**HURLSTONE AGRICULTURAL HIGH
SCHOOL (HAWKESBURY)**

ACCESS REVIEW

HASH-00-SD-AC-RP-B

22 September 2017

BUILDING 02 - GROUND FLOOR

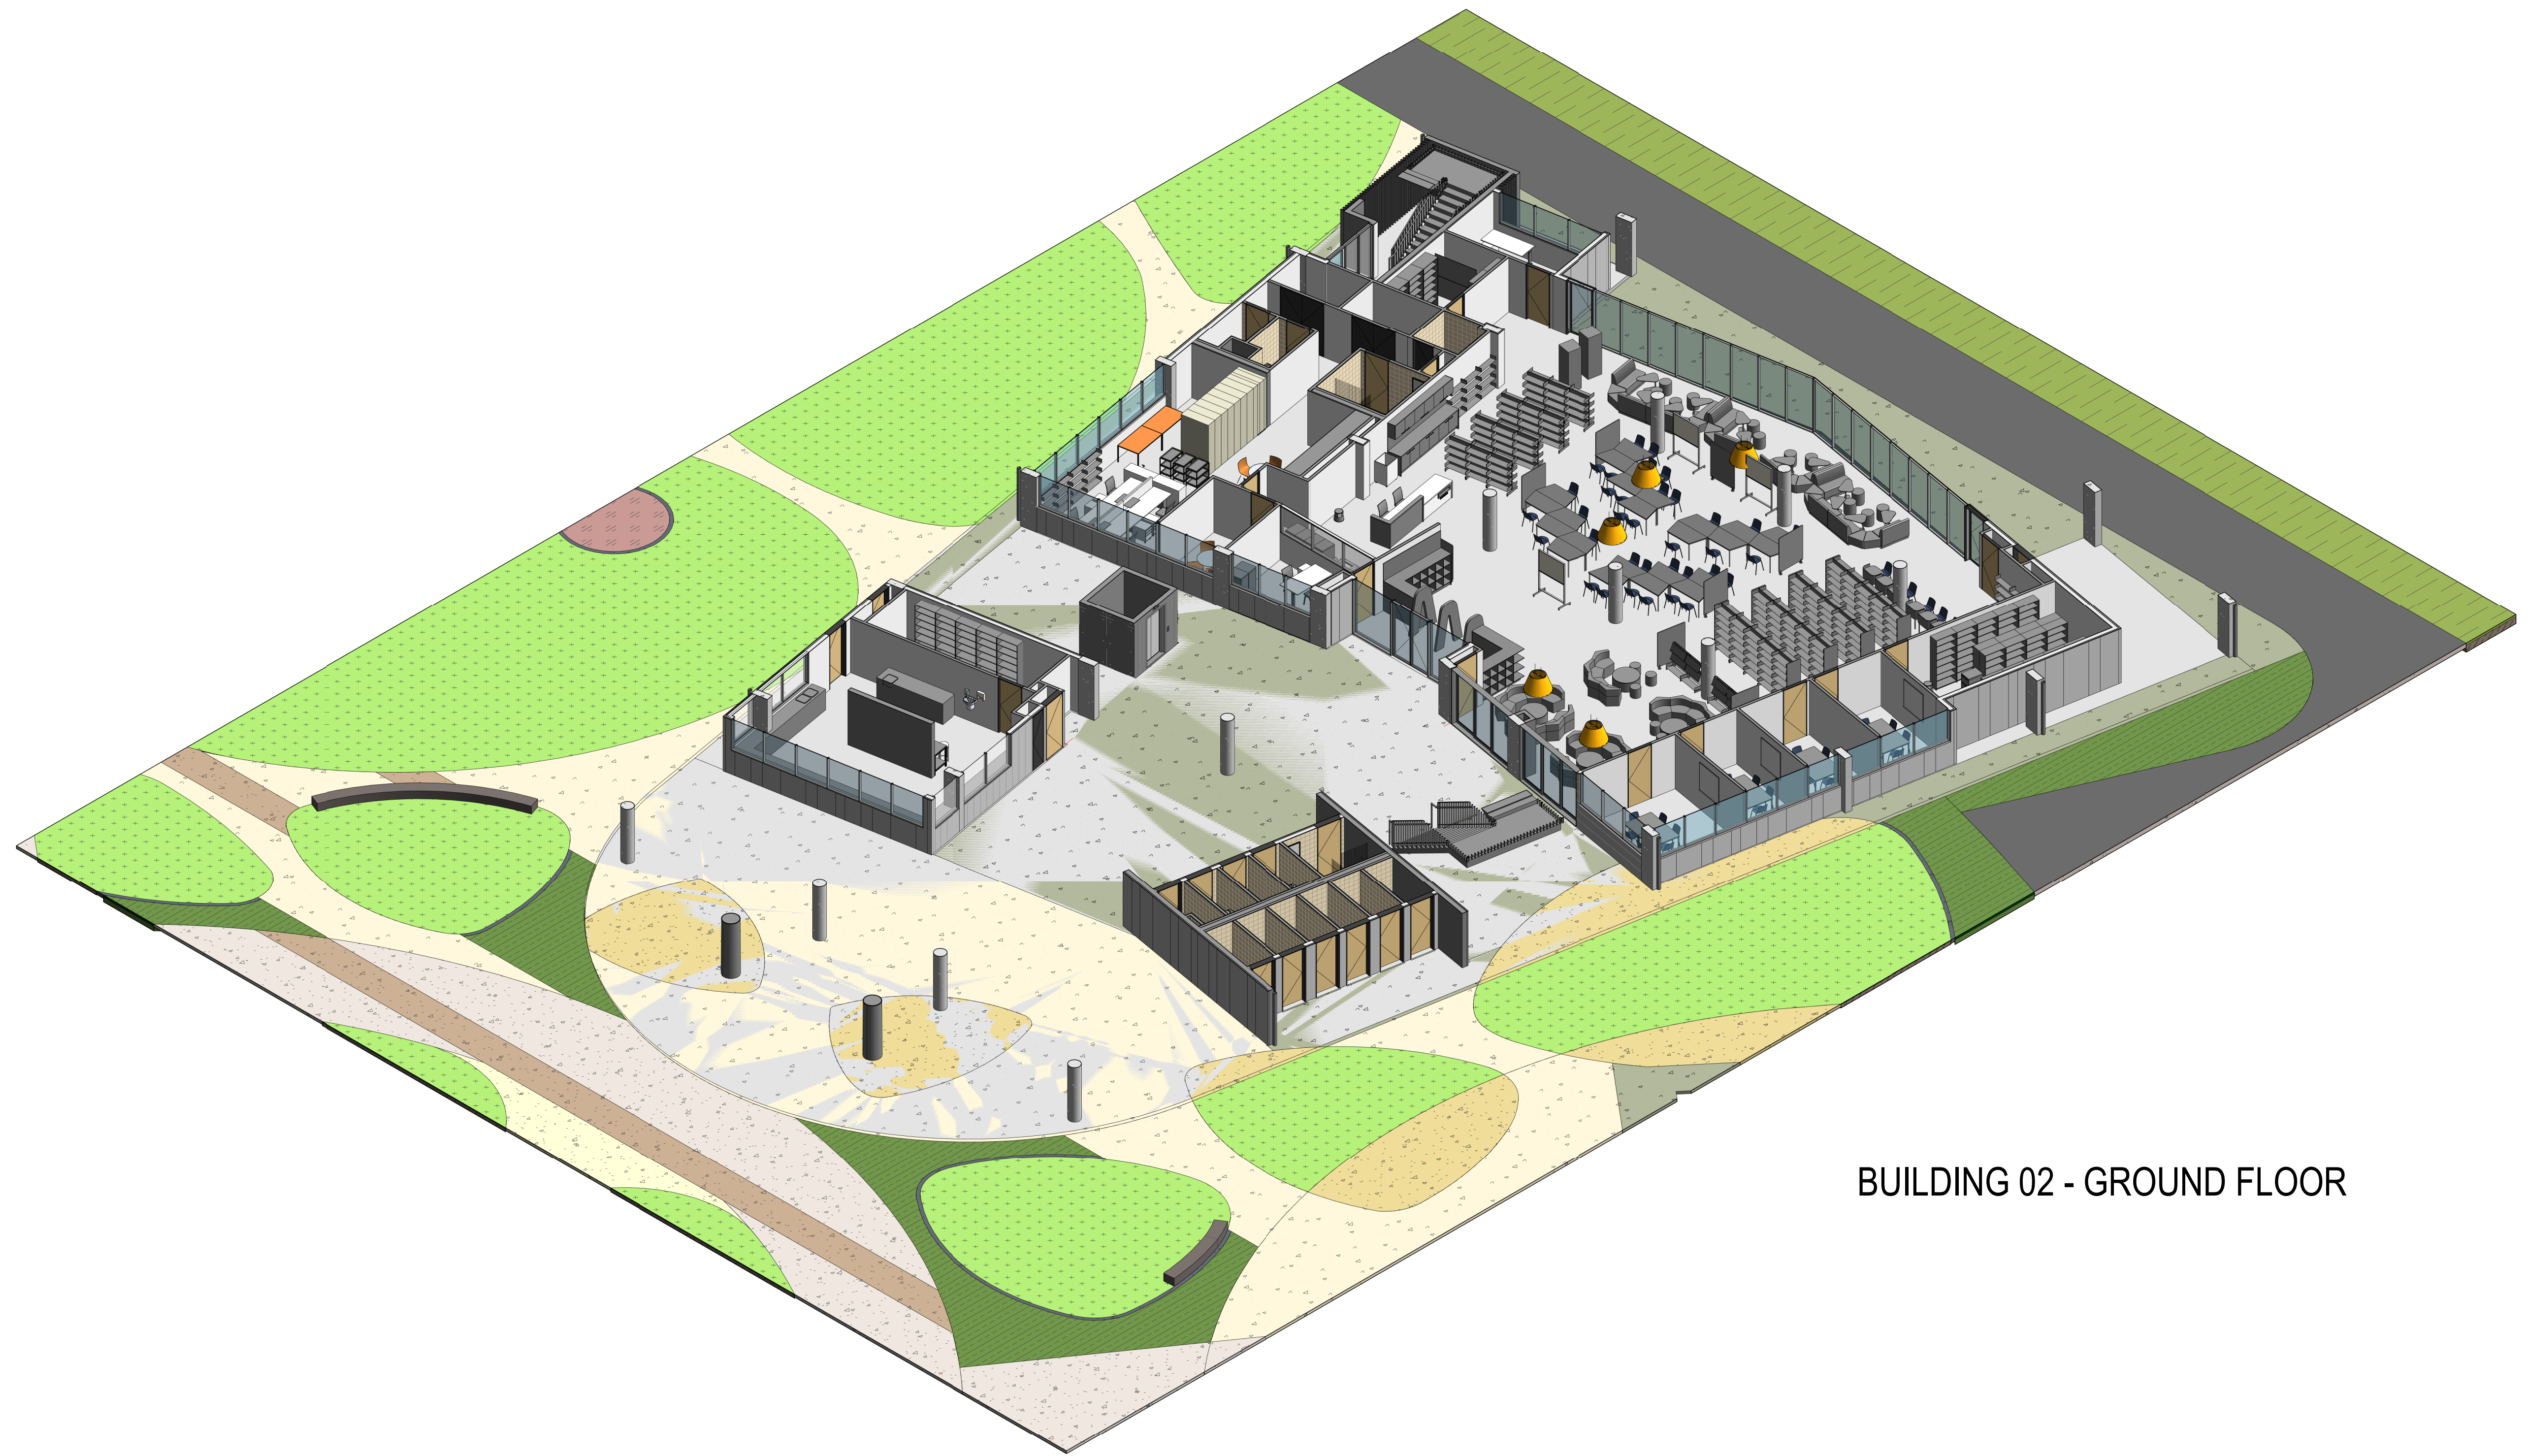
Amendments are required at Building 02 and Building 03 to mirror the configuration of some toilets. At present all of the accessible toilets in these buildings are shown as LH transfer WC pans. Reversing the configuration on Level 01 at Building 03 and on Level 02 and Ground Level (building interior) of Building 02 is the most equitable approach.

- (i) Provide details at CC stage demonstrating compliance of the accessible toilets to the requirements of AS1428.1, including reversal of configuration to certain toilets to meet the requirement for even balance of transfer WC pans.

PROJECT No:
16 052
SCHOOL ID PAC ID STAGE DISC. TYPE DRAWING No. REV:
HASH-03-DD-AR-DR-2100-H

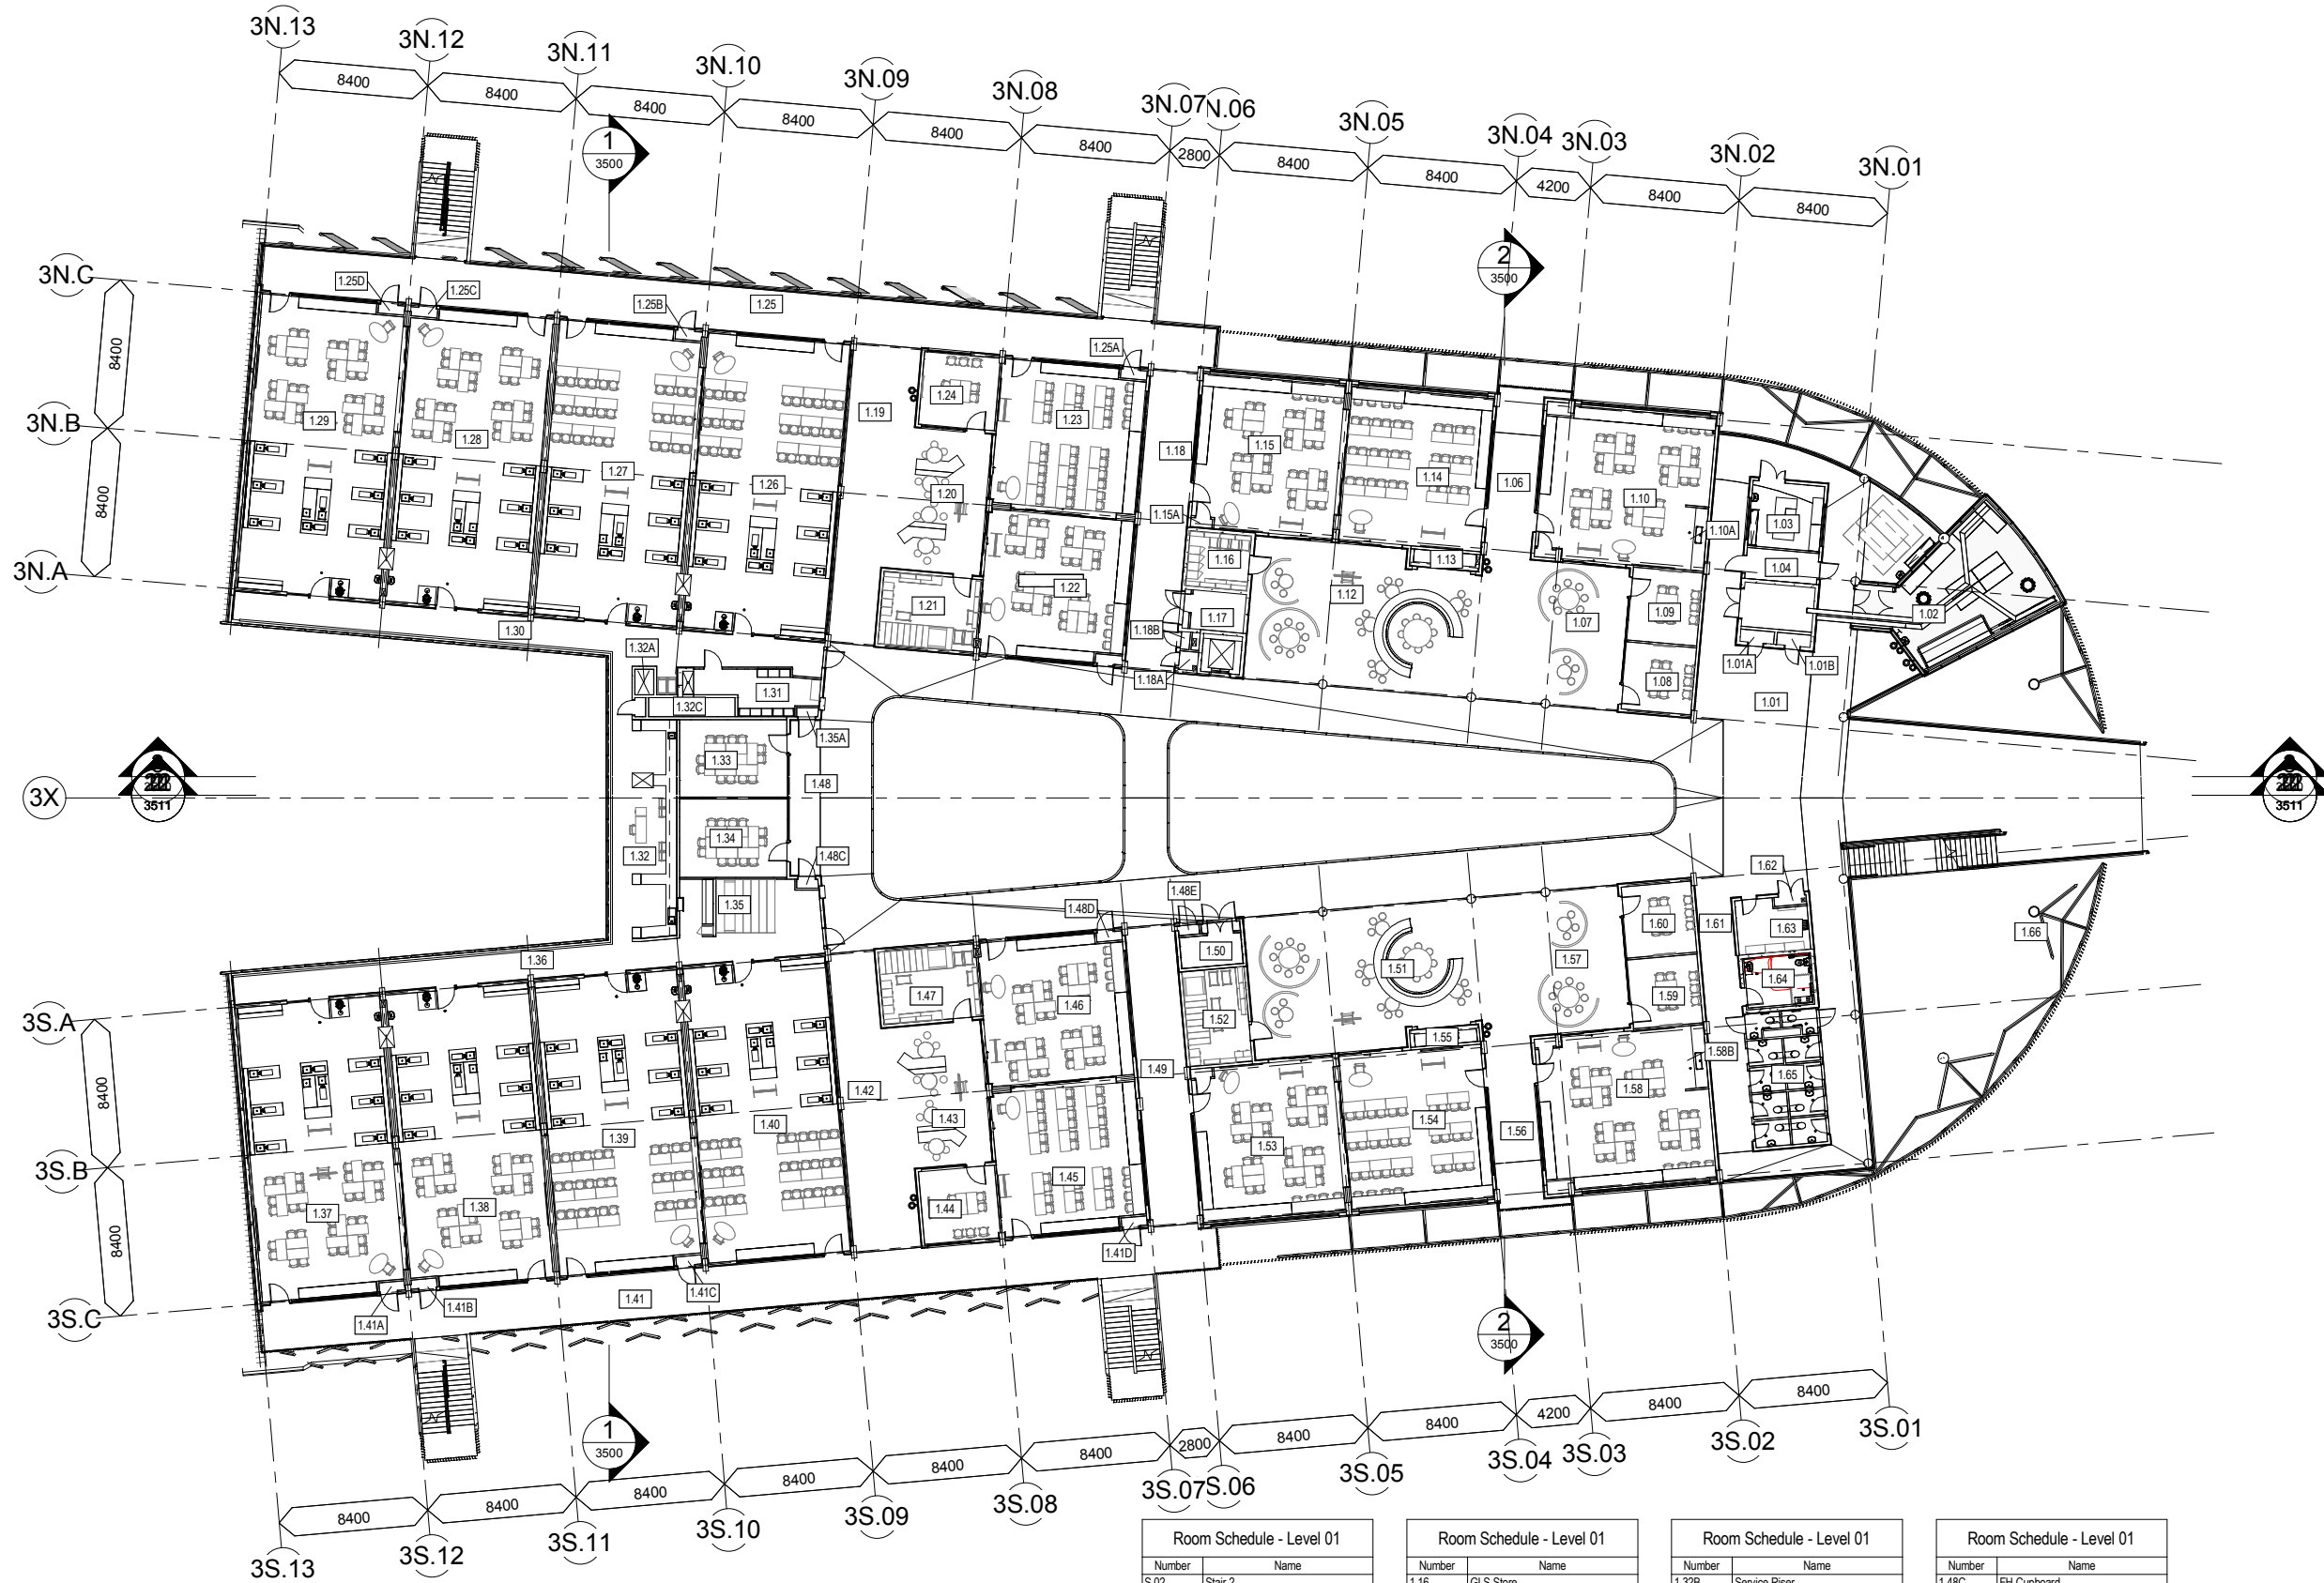
- (i) Review the required circulation area forward of all common use doors and make amendments where impeded by fixed furniture or other obstructions.
- (ii) The use of sliding doors is common, particularly at Building 02 and Building 03. Often these doors are paired with a hinged type which is expected to offer the accessible door, however in some cases the sliding door is not paired with a hinged type and it is not always clear on which panel in the arrangement is intended as the operable leaf. Review is required of door circulation at the active leaf, particularly where the door appears to be presently impeded by joinery or located to close to an internal corner of the room. Note, sliding doors dividing areas on the floor, which are not used as the principal entrance into the room, and which do not achieve the required circulation can be supported as such under a Performance Solution as the decision to open or close these would be made by staff and operated by able bodied staff.

The passenger lifts are appropriately located within the layouts, reducing travel to reasonable distances and being close to base building amenities. Due to the large size of Building 03 it is recommended that an additional lift is inserted into the layout (ideally near the front of the building for visibility) to further reduce travel distance, and provide a more equitable distribution of accessible and non-accessible vertical transport. Under the DDA Premises Standards non-accessible pedestrian entrances to buildings must be no further than 50m to an alternative accessible entrance to the building. MGAC apply similar logic to the location of accessible and non-accessible means to travel between floors in a building i.e. a non-accessible accessway between floors e.g. stair, ideally must be no further than 50m from an accessible accessway between floors e.g. lift or ramp. The provision of an additional lift at Building 03, in addition to reducing the distances between accessible and non-accessible vertical transport, will also provide backup for lift maintenance or breakdown. Such measures may mitigate potential DDA complaints.

- (i) Provide details at CC stage demonstrating compliance of the passenger lifts with the requirements of AS1735.12.
- (ii) Consider an additional passenger lift near the front of Building 03, to further reduce travel distances in the building to the nearest lift, and also to reduce the distance between lifts and stairs, and in the process provide for backup in the event of lift maintenance or breakdown (advisory).
